# London Luton Airport Expansion

**8.114 Applicant's Response to Deadline 4 Submissions  
Appendix B - Dacorum Borough Council, Hertfordshire County  
Council & North Hertfordshire Council (Response to D3  
Documents) (REP4-163)**

Application Document Ref: TR020001/APP/8.114

Figure 32 Growth in trip productions by mode in NTEM 8 and NTEM 7.2

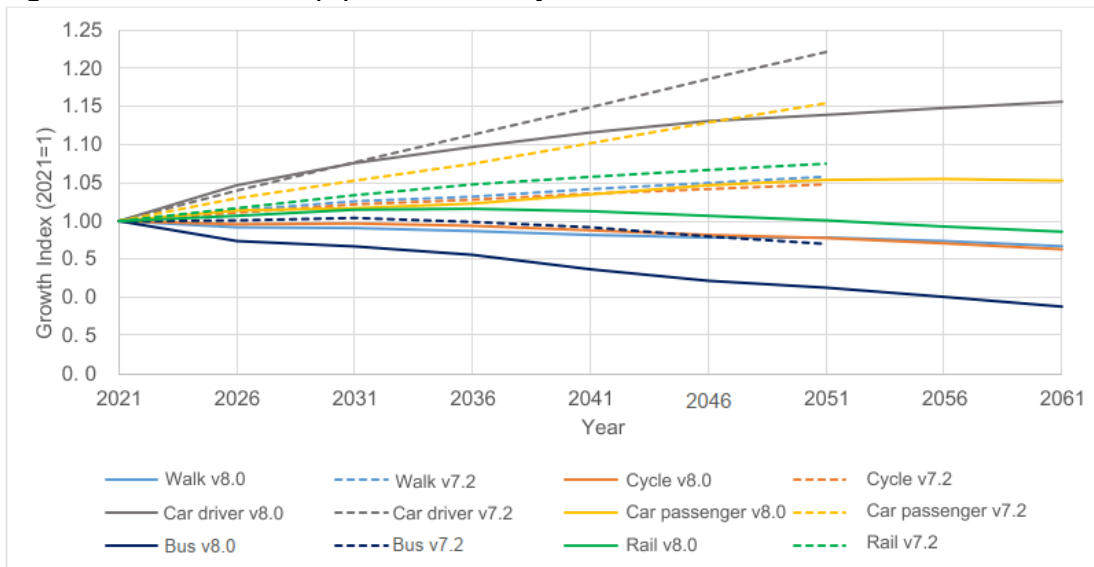
28	Surface Access	<p>Matters Raised</p> <p>Page 21 Slide 19 Growth in trip productions by mode</p> <p>Host Authorities Comments</p> <p>The Applicant should confirm whether this graph is showing National or Local Growth Productions by mode.</p>	<p>The graph shows national data. Please also see <b>Volume 8 Additional Submissions (Examination) 8.98 Applicant's Response to Issue Specific Hearing 4 Action 2: Covid 19 Additional Modelling Technical Note 1 Trends Analysis. [REP4-086].</b></p>
29	Surface Access	<p>Matters Raised</p> <p>Page 22 Slide 20 Growth in all trip productions through time</p> <p>Host Authorities Comments</p> <p>The Applicant should confirm whether this graph is showing National or Local Growth Productions by mode.</p>	<p>The graph shows national data. Please also see <b>Volume 8 Additional Submissions (Examination) 8.98 Applicant's Response to Issue Specific Hearing 4 Action 2: Covid 19 Additional Modelling Technical Note 1 Trends Analysis. [REP4-086].</b></p>

Figure 34 Trip productions by purpose - % change from 2021 to 2051 in NTEM 7.2 and NTEM 8.0

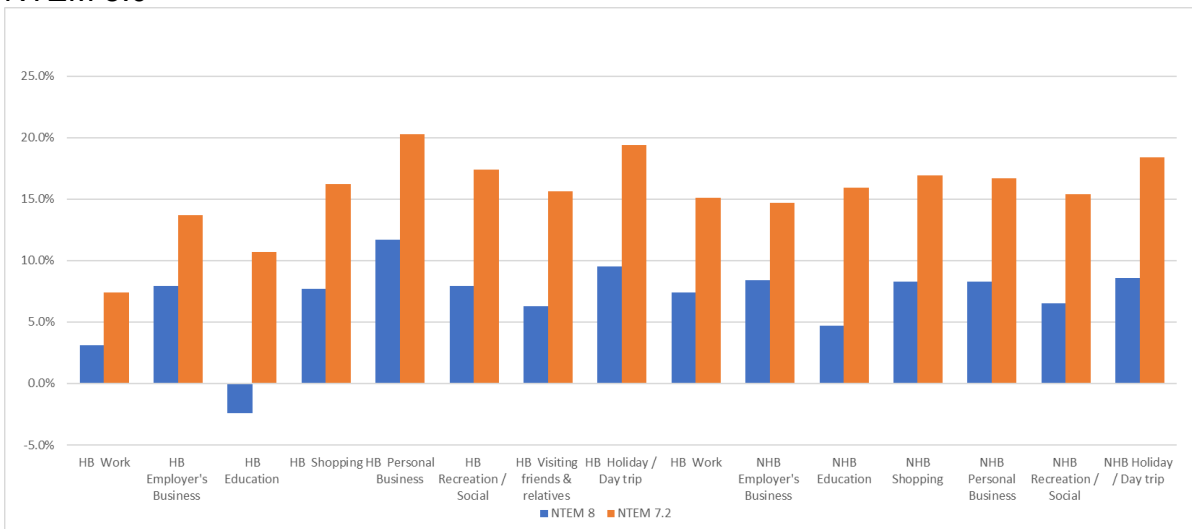
I.D.	Topic	Deadline 4 submission (Verbatim)	Luton Rising's Response
30	Surface Access	<p>Matters Raised</p> <p>Page 23 Slide 21 Trip productions by purpose - % change 2021-2051</p> <p>Host Authorities Comments</p> <p>The Applicant should confirm whether this graph is showing National or Local Growth Productions by mode.</p>	<p>The graph shows national data. Please also see <b>Volume 8 Additional Submissions (Examination) 8.98 Applicant's Response to Issue Specific Hearing 4 Action 2: Covid 19 Additional Modelling Technical Note 1 Trends Analysis. [REP4-086].</b></p>
31	Surface Access	<p>Matters Raised</p> <p>Covid-19 Modelling</p> <p>Host Authorities Comments</p> <p>"Demand model and highway assignment model runs taking place for reporting in October, including new 2023 forecast year and comparison with count data." The Applicant should confirm the methodology adopted to produce the 2023 forecast matrices.</p>	<p>This is documented in <b>Volume 8 Additional Submissions (Examination) 8.109 Applicant's Response to Issue Specific Hearing 4 Action 2: Covid 19 Additional Modelling Technical Note 2 Risk Assessment. [REP4-106].</b></p>
